Re: AU-11-00003

Thank you for the opportunity to comment on the notice of application for the addition of an accessory dwelling, proposed by Lon Crosslin. We have reviewed the application and have the following comment.

TO: Jeff Watson
FROM: Christina Wollman, Planner II *CW*
DATE: August 17, 2011
SUBJECT: Crosslin Accessory Dwelling Unit AU-11-00003

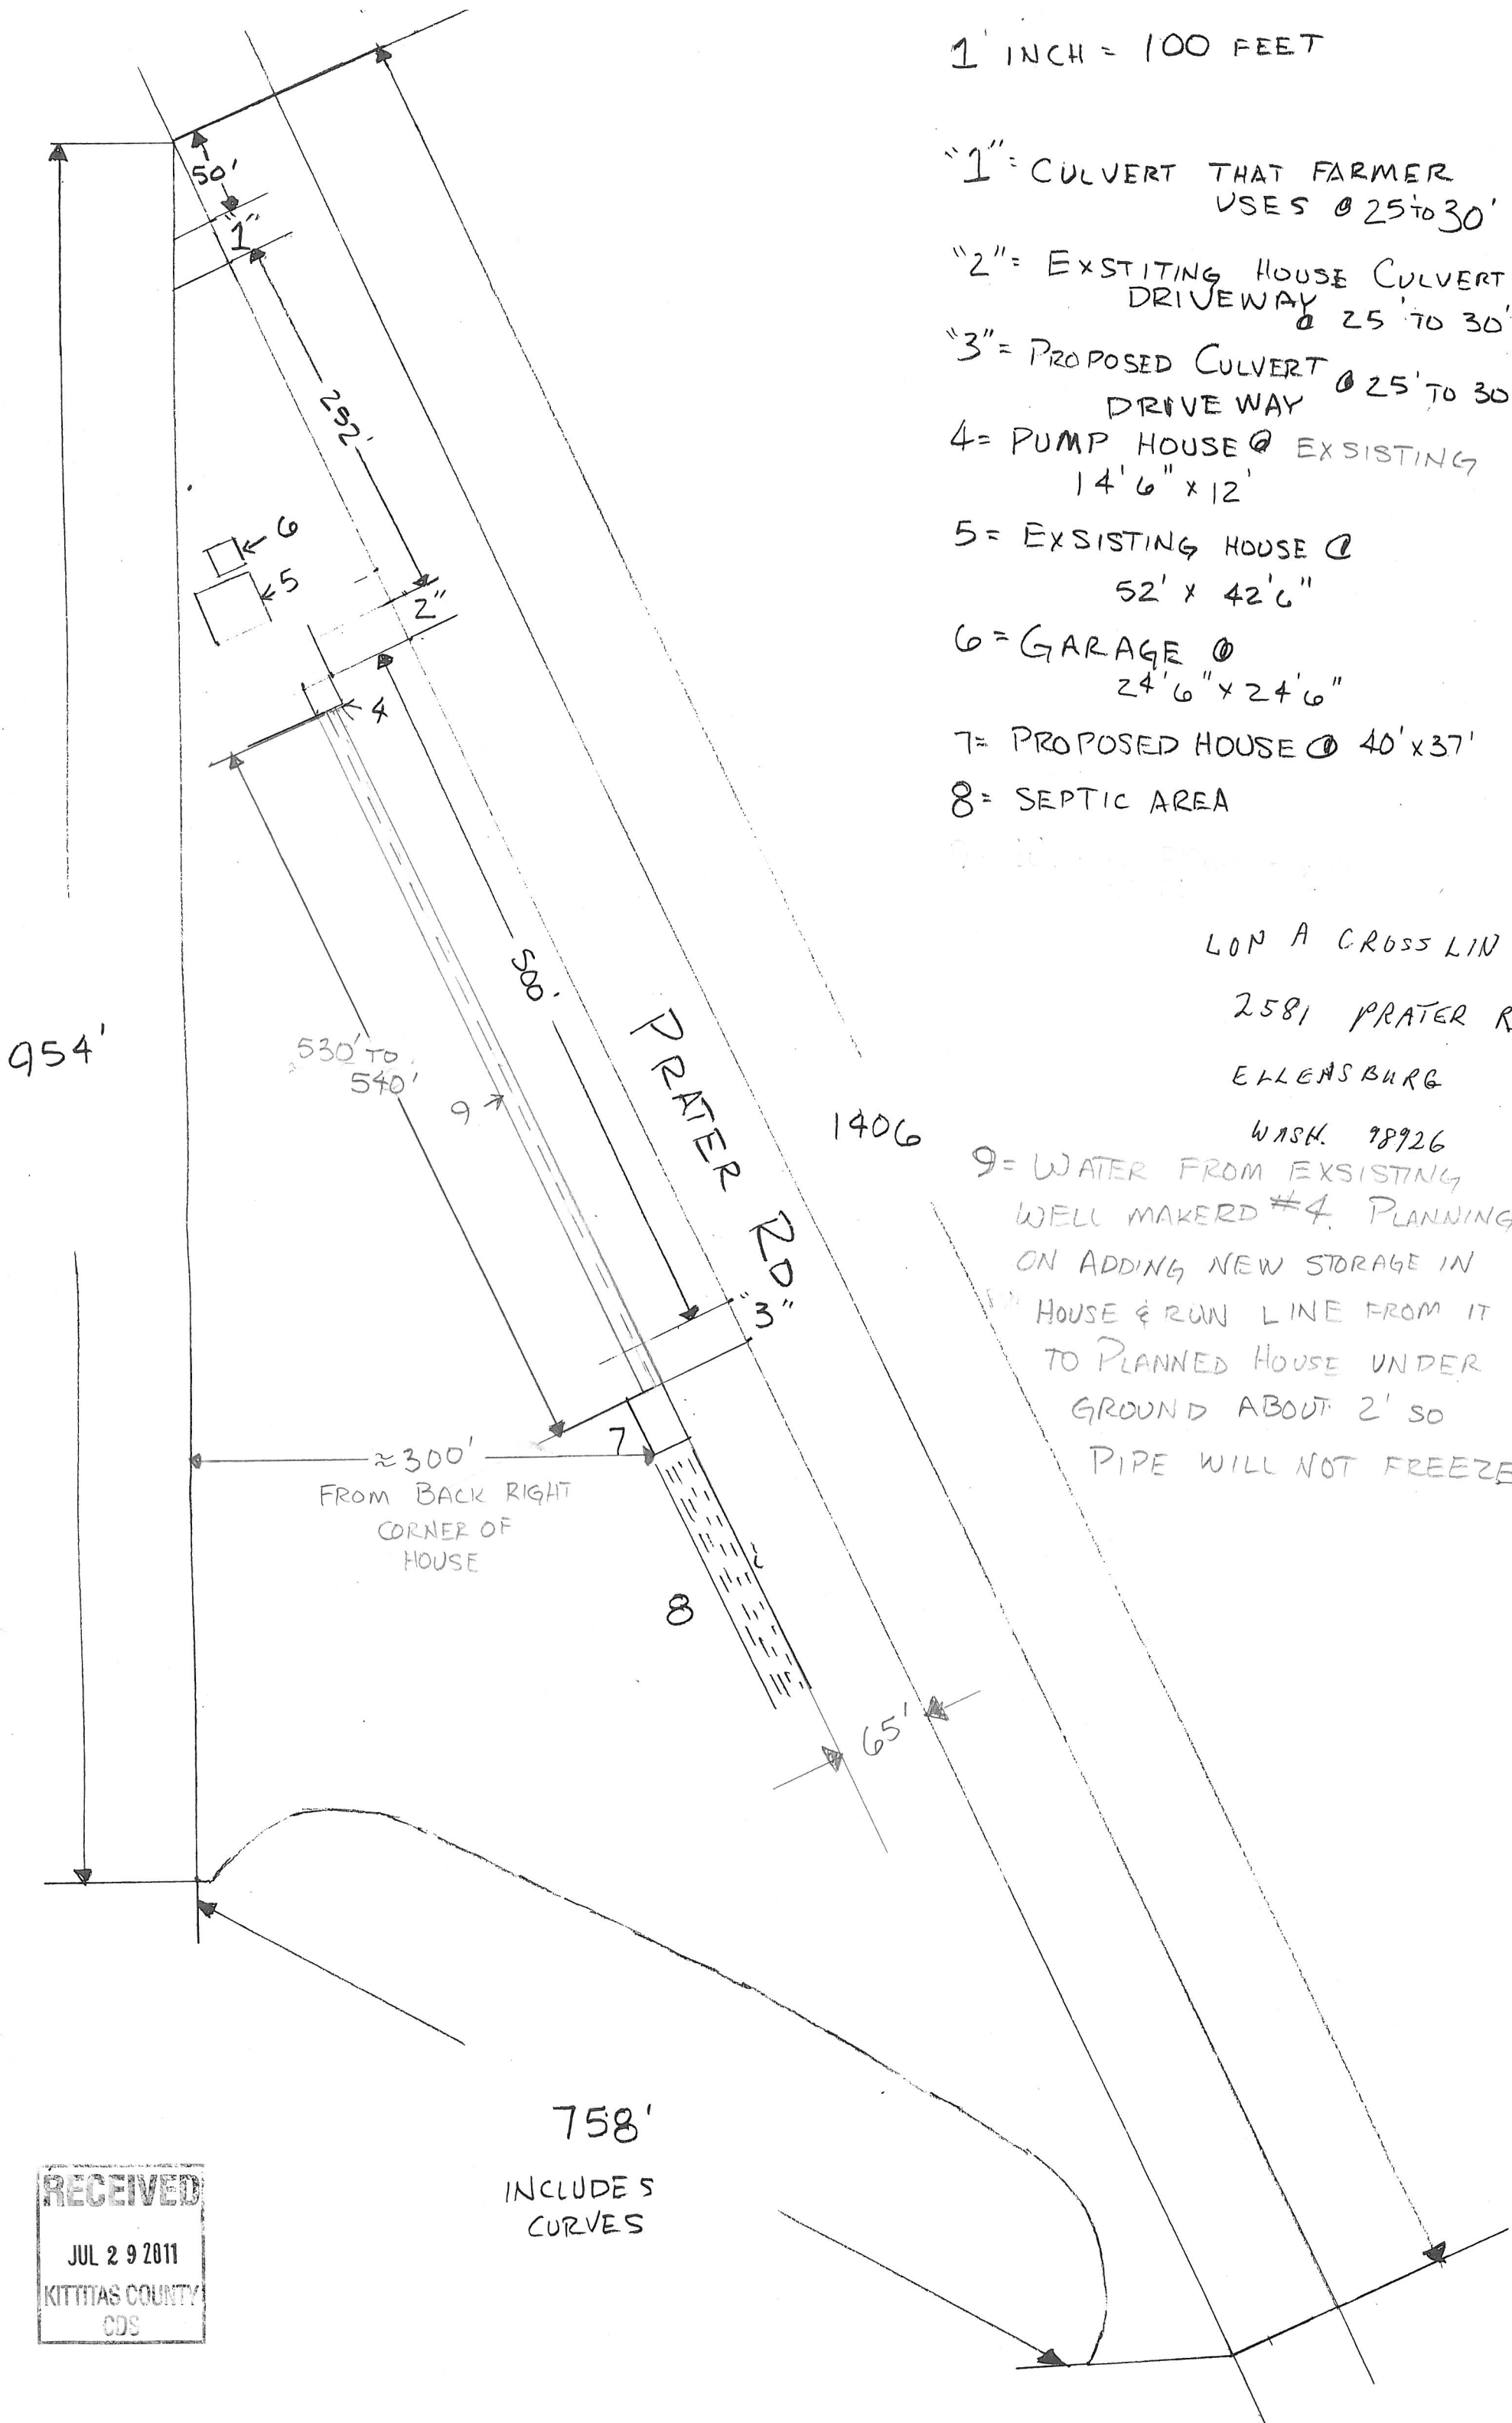
- A. Access: The applicant was issued Road Variance 11-03 allowing a second access onto the property at the location identified on the application. Prior to constructing the driveway, the applicant must apply for an access permit.
- B. Addressing: Contact the Kittitas County Rural Addressing Coordinator at (509) 962-7523 to obtain addresses prior to obtaining a building permit. A parcel cannot receive a building permit or utilities until such parcel is identified with a 911 address.
